Applicant: 15 Waller St.

Permit # 2015-00895

CHECK-LIST AGAINST ZONING ORDINANCE

Interior or corner lot - rebuild nonconforming - set backs & use - three unit building
 Proposed Use/Work - footprint attached garage - 28' x 24.5' = 686
 building 27' x 28' x 47' = 1316
 w/ 3' x 12.75' = 38.25

20 NORTH ELEVATION
 SCALE: 1/4" = 1'-0"

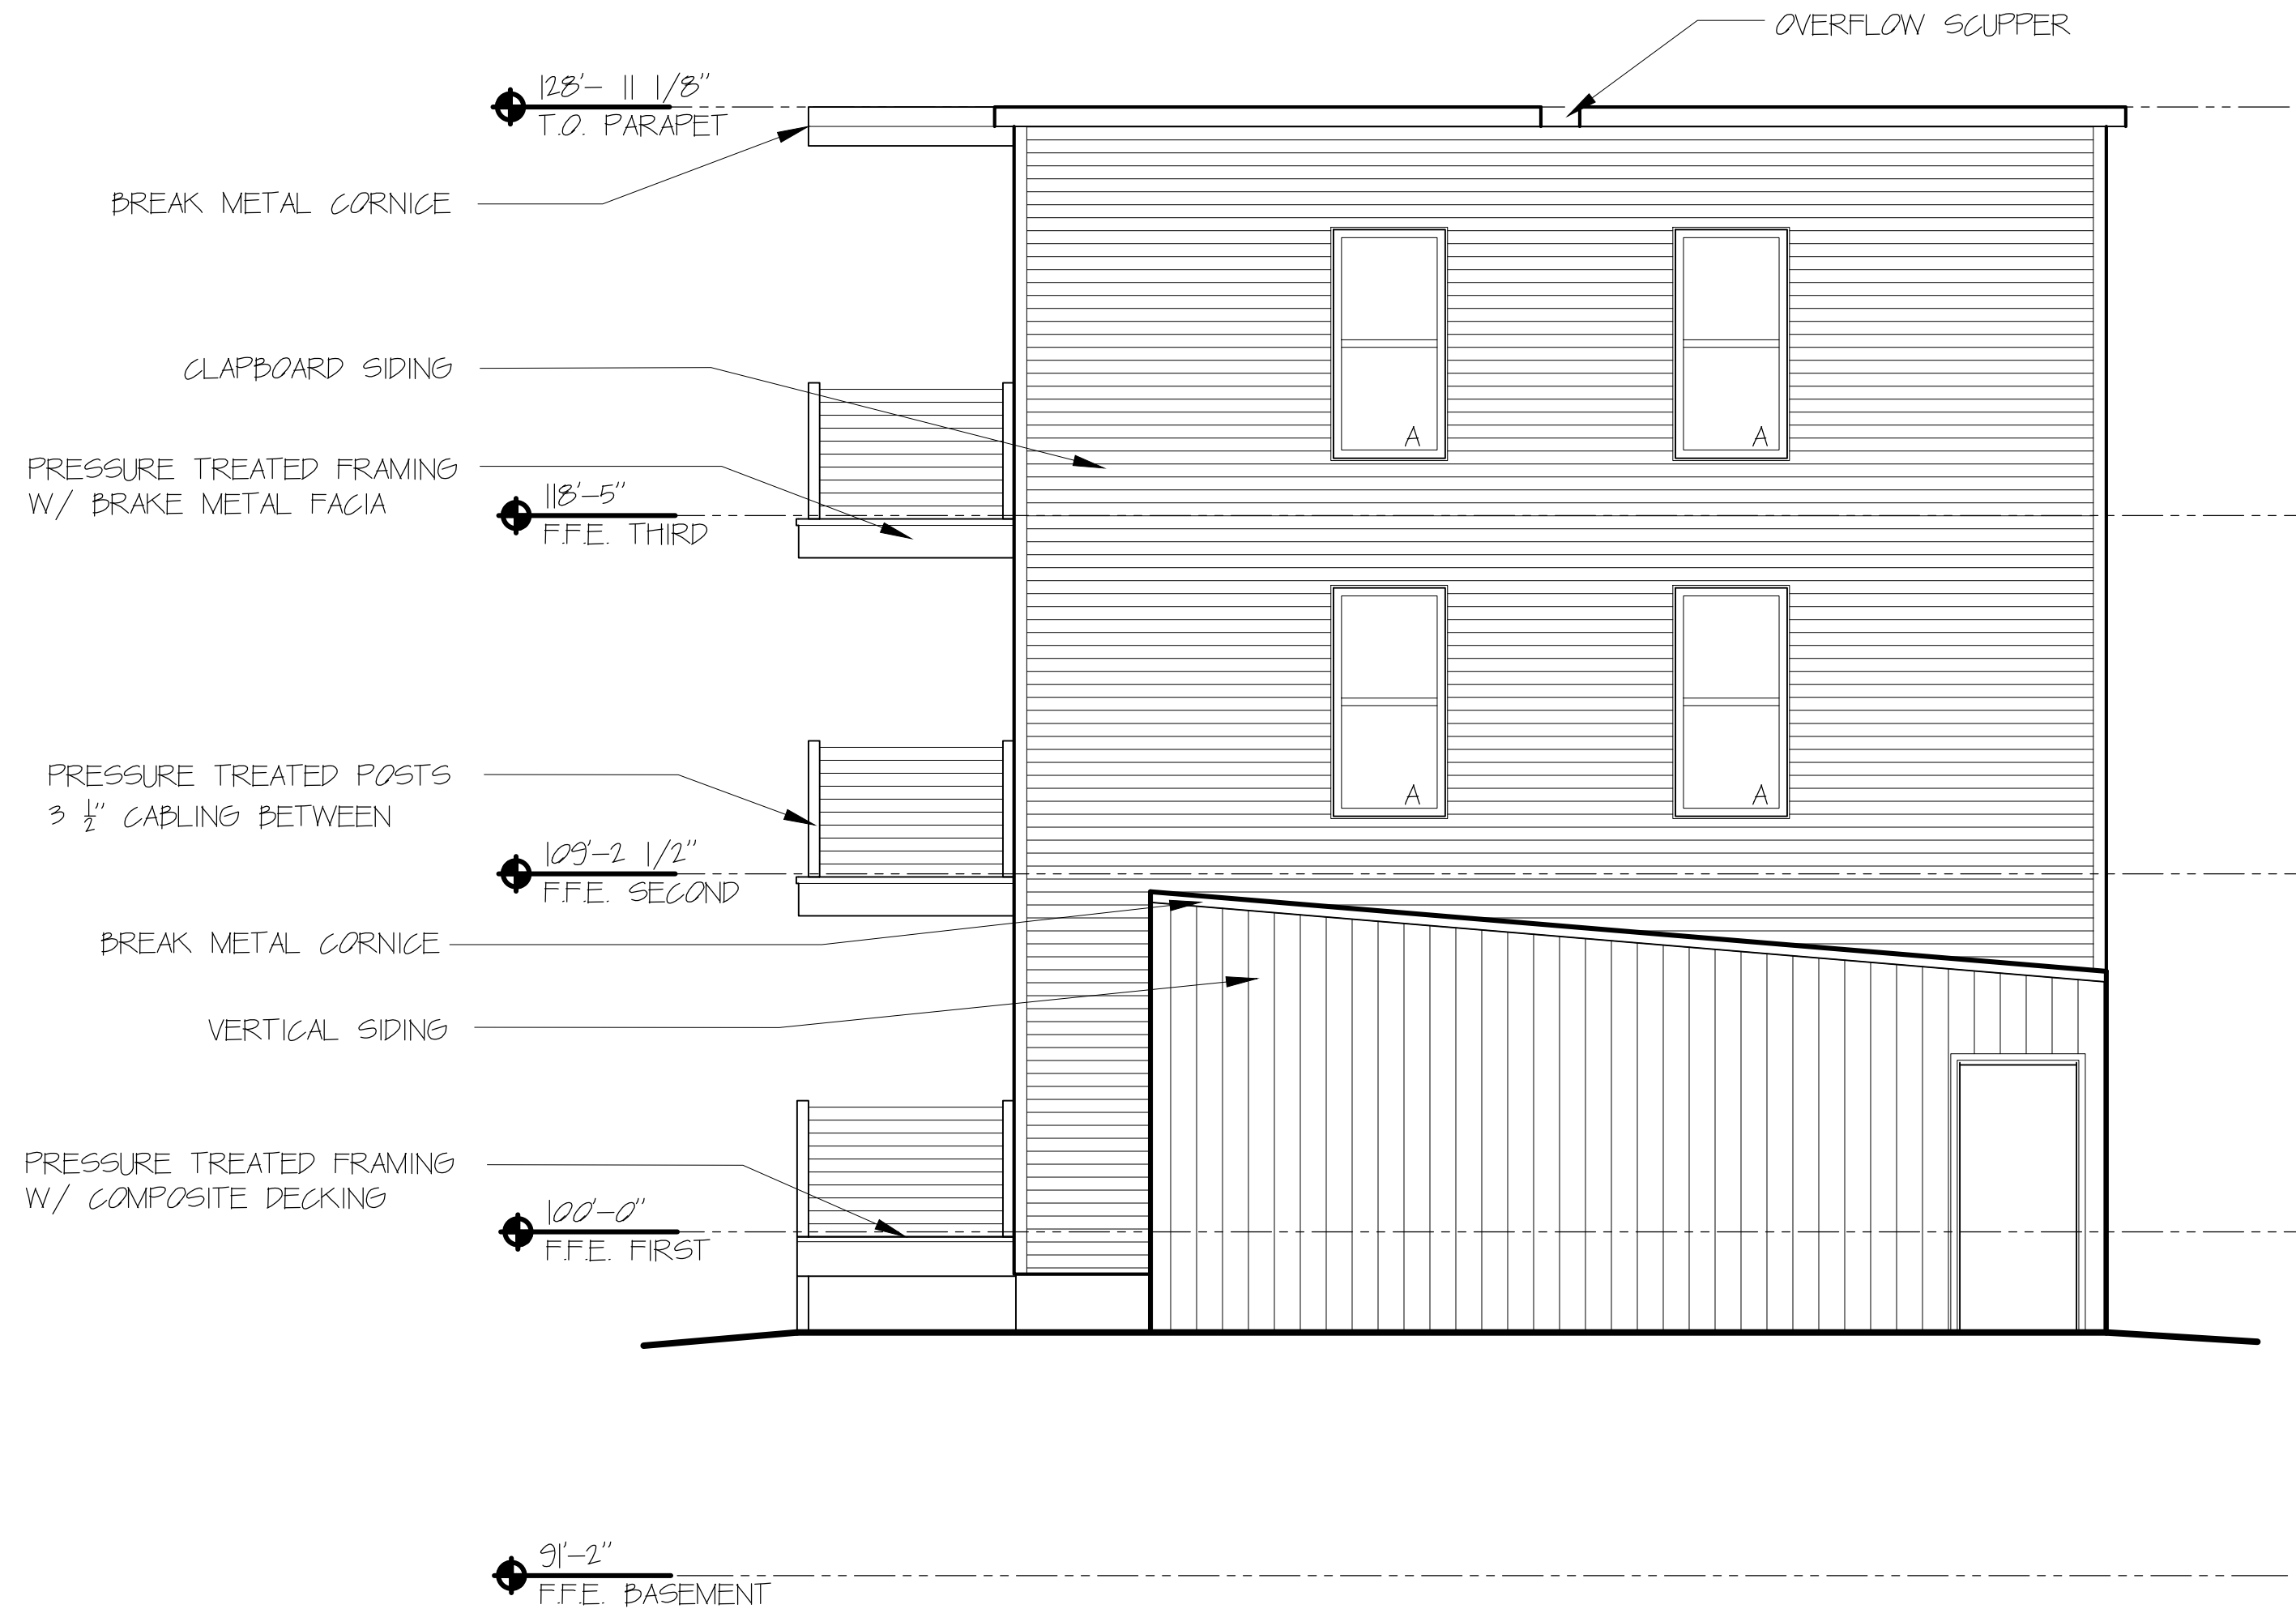
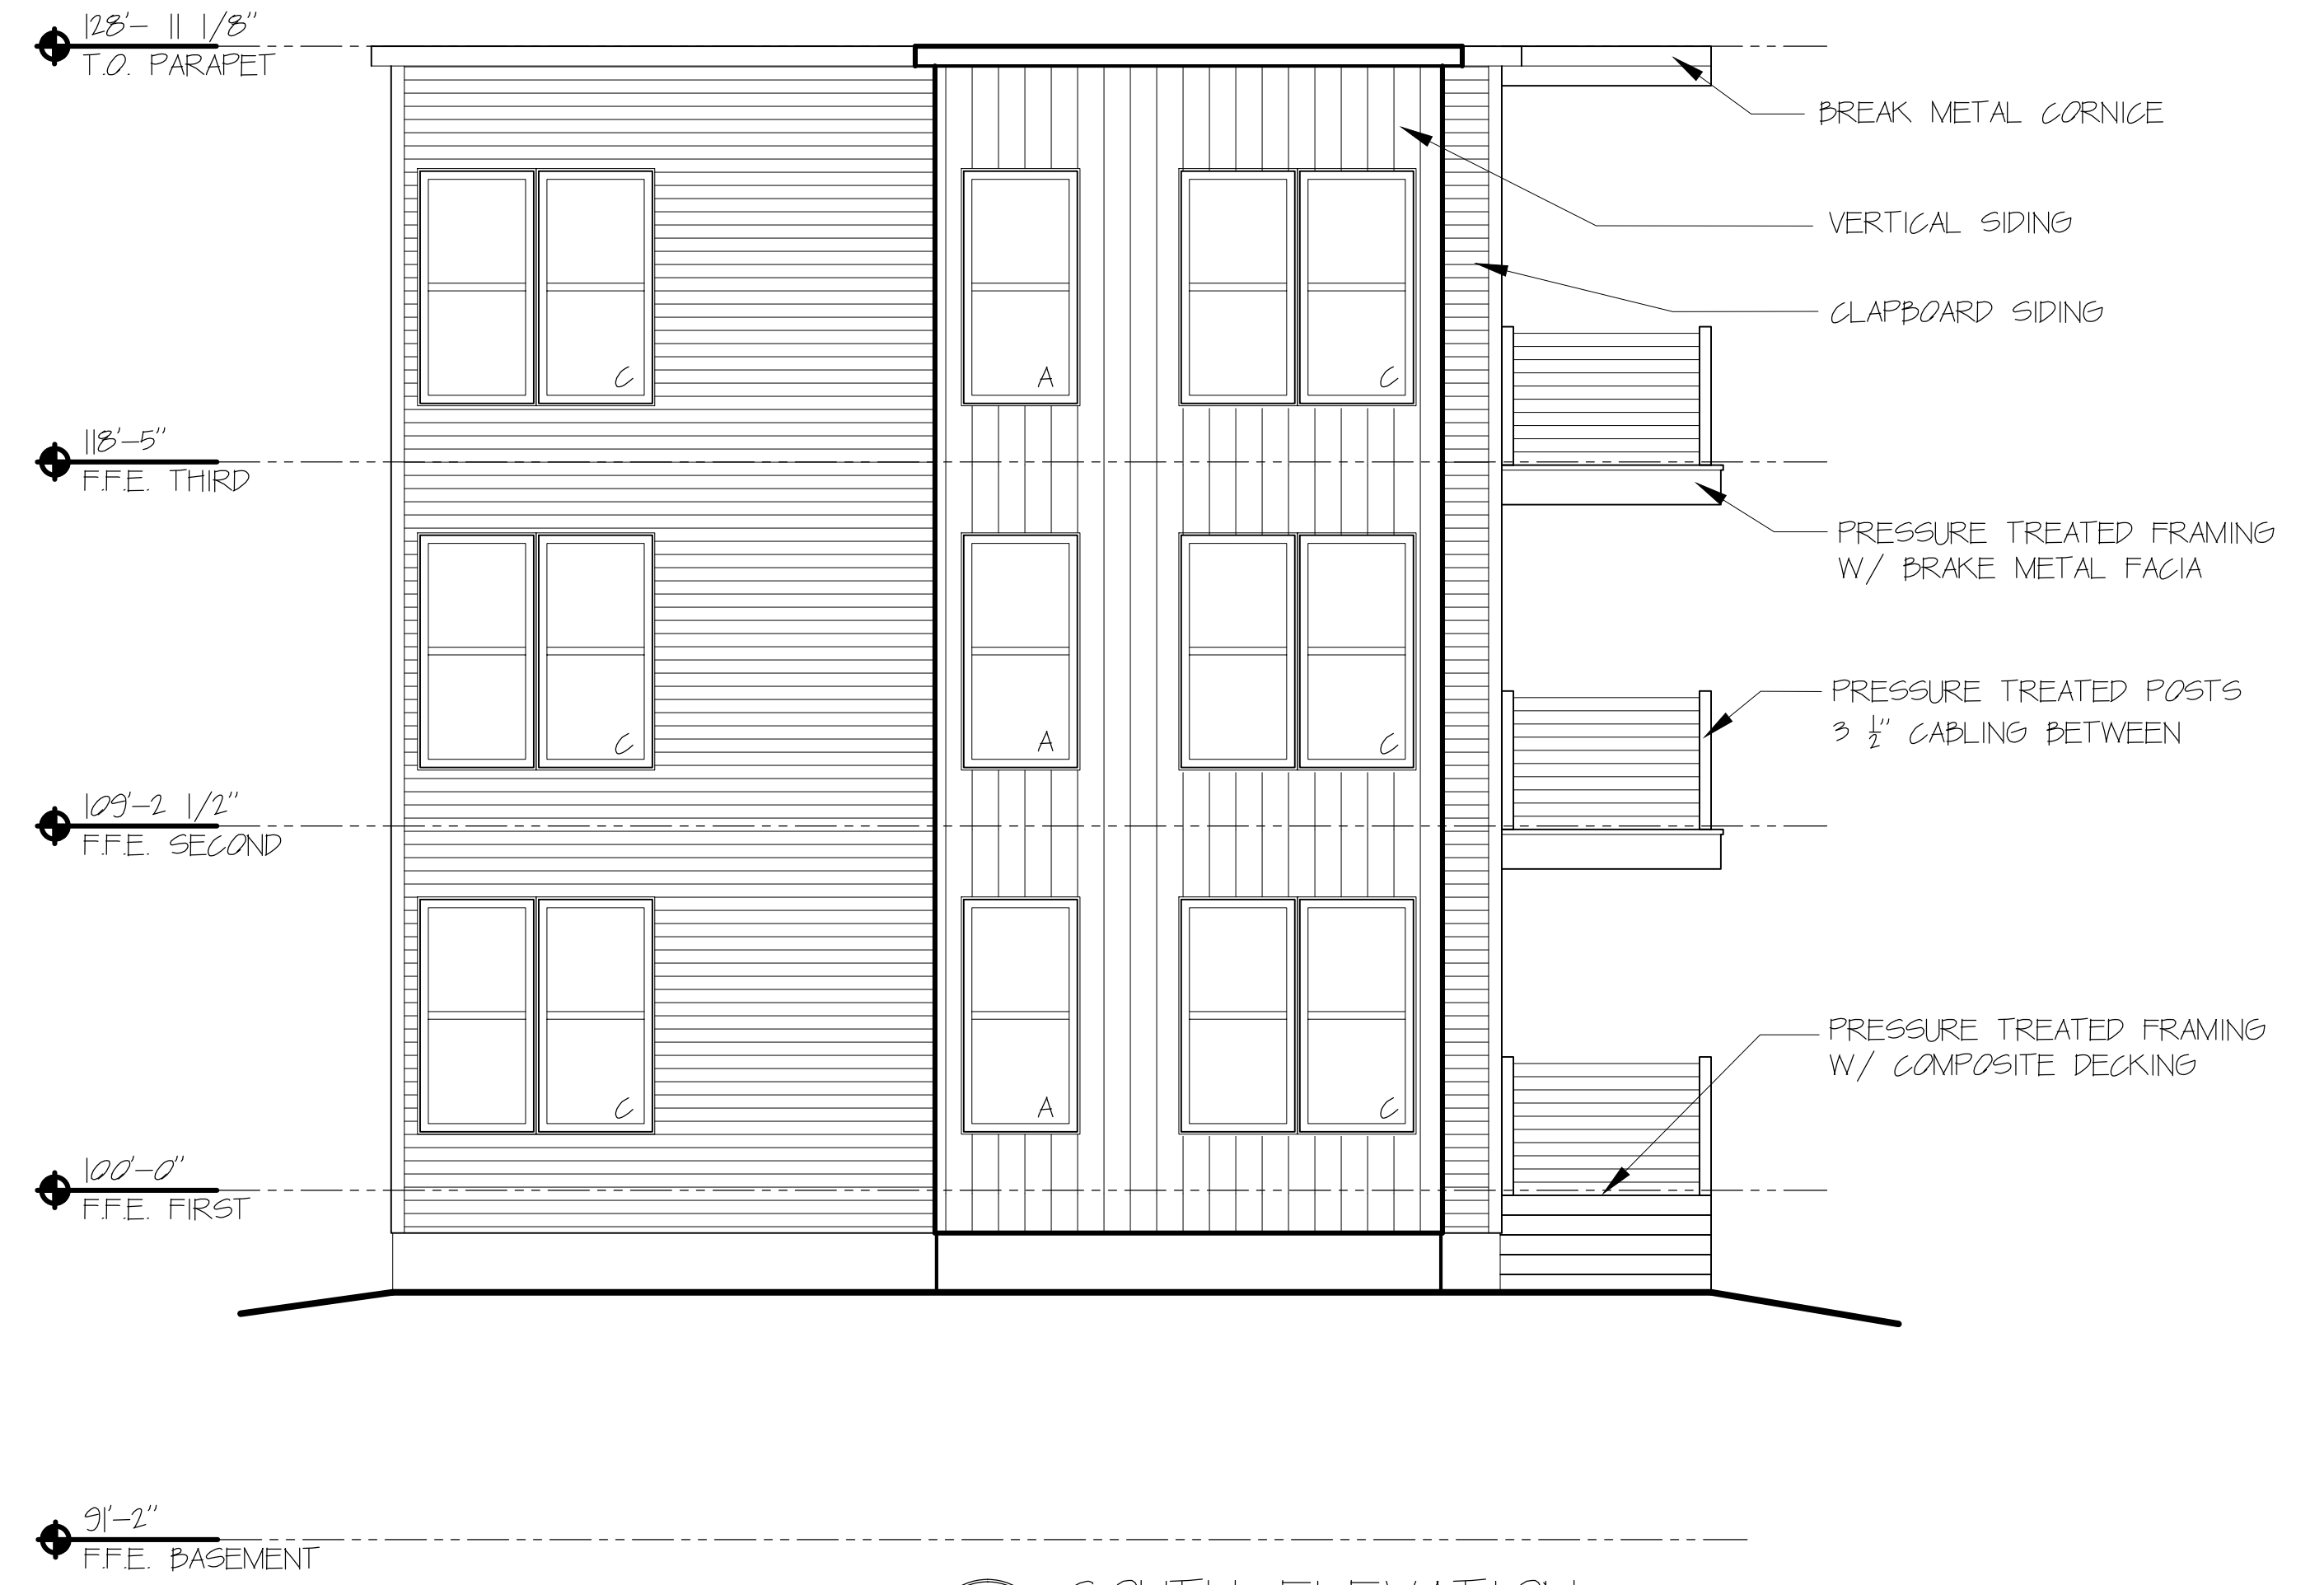
Height - 35' max - 31.67' scaled - 79/9 ft 14-385 extended with 10/21/15
 216.25 proposed OK

- original garage was 24' x 30' - replacement (OK)
 - * original building was hip roof but - flat roof not as high as ridge
 volume would be similar OK - 14-385

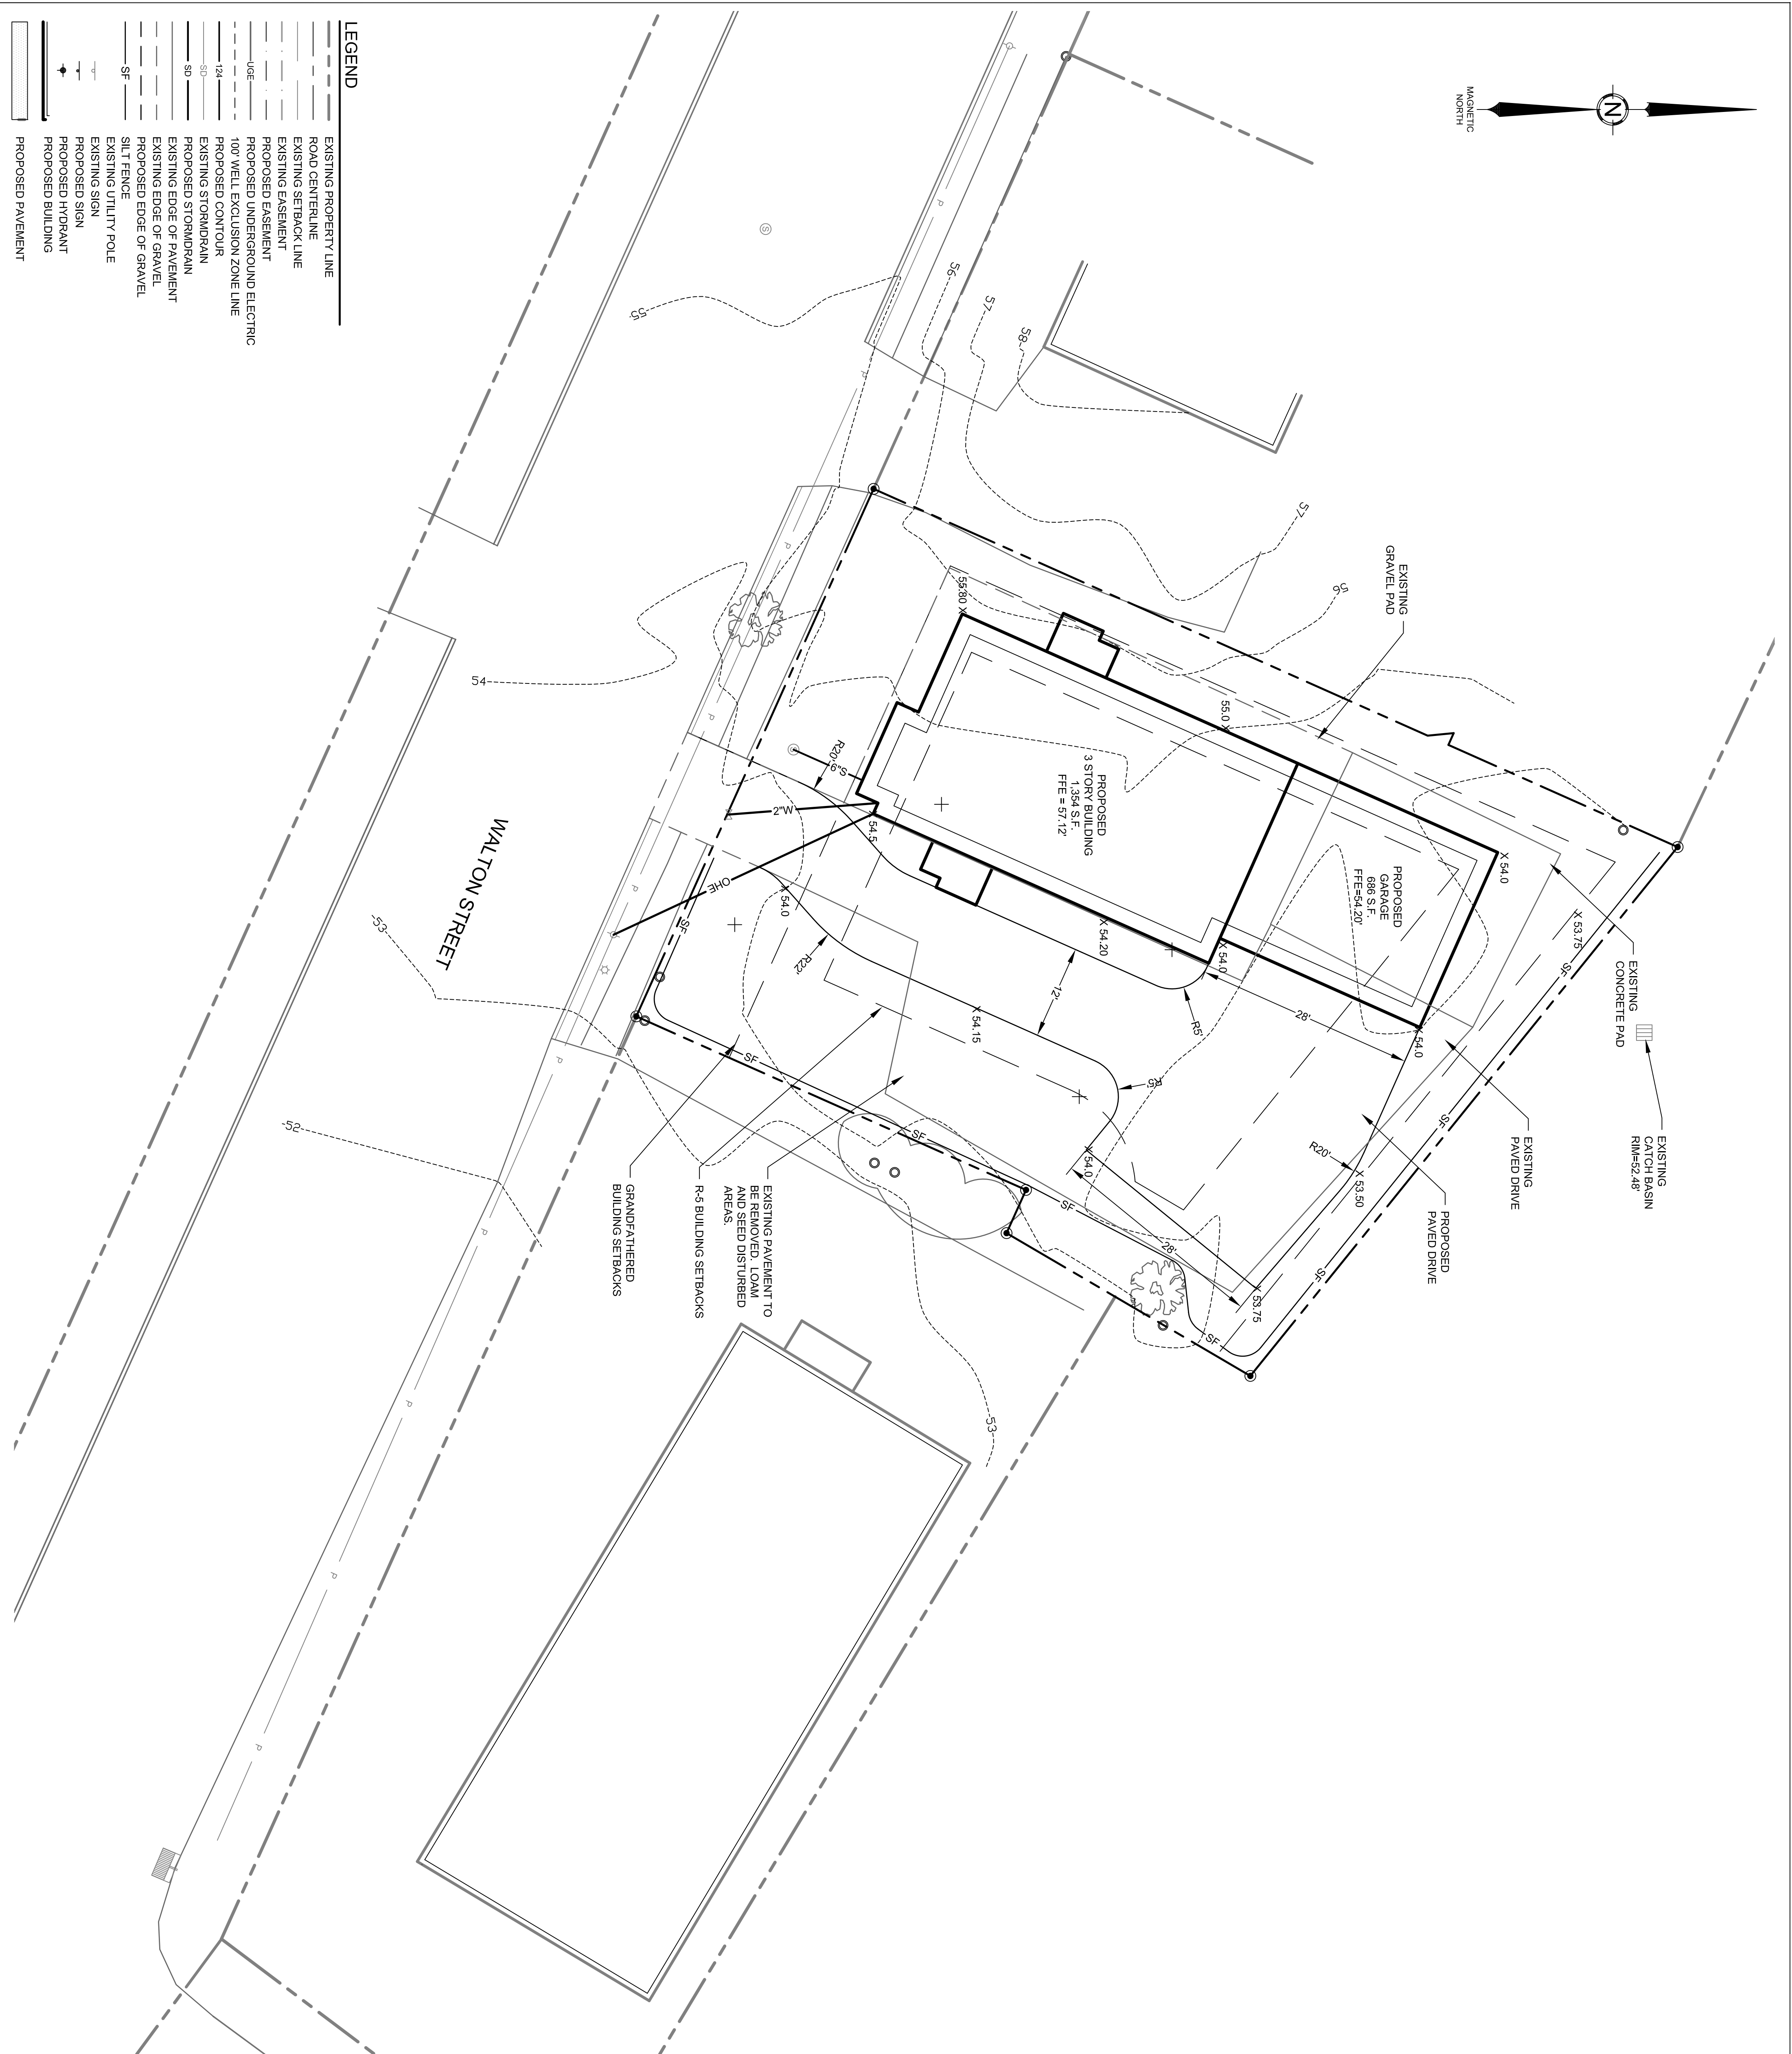
Lot Street Frontage - 50' min - 74' (OK)

Front Yard - 20' or average - * using section 14-385 - w/ 13' now - 14.15' (OK) - average is 13.25' (OK)

Rear Yard - 20' min - 11.7' scaled - OK - less nonconforming than original garage

Side Yard - 2 1/2 stories - 14' - 10' on left scaled - OK can reduce one yard to 8' if 28' bld in setback
 * landing using 14-425 (OK)
 - 36' on right

Projections - 2 sets of entry porches - 5.33 x 5.6' + 4 x 2.6' = 18.4 = 40.
 5.33 x 15.88' deck = 83.4

Lot Coverage Impervious Surface - 40% = 3167.6
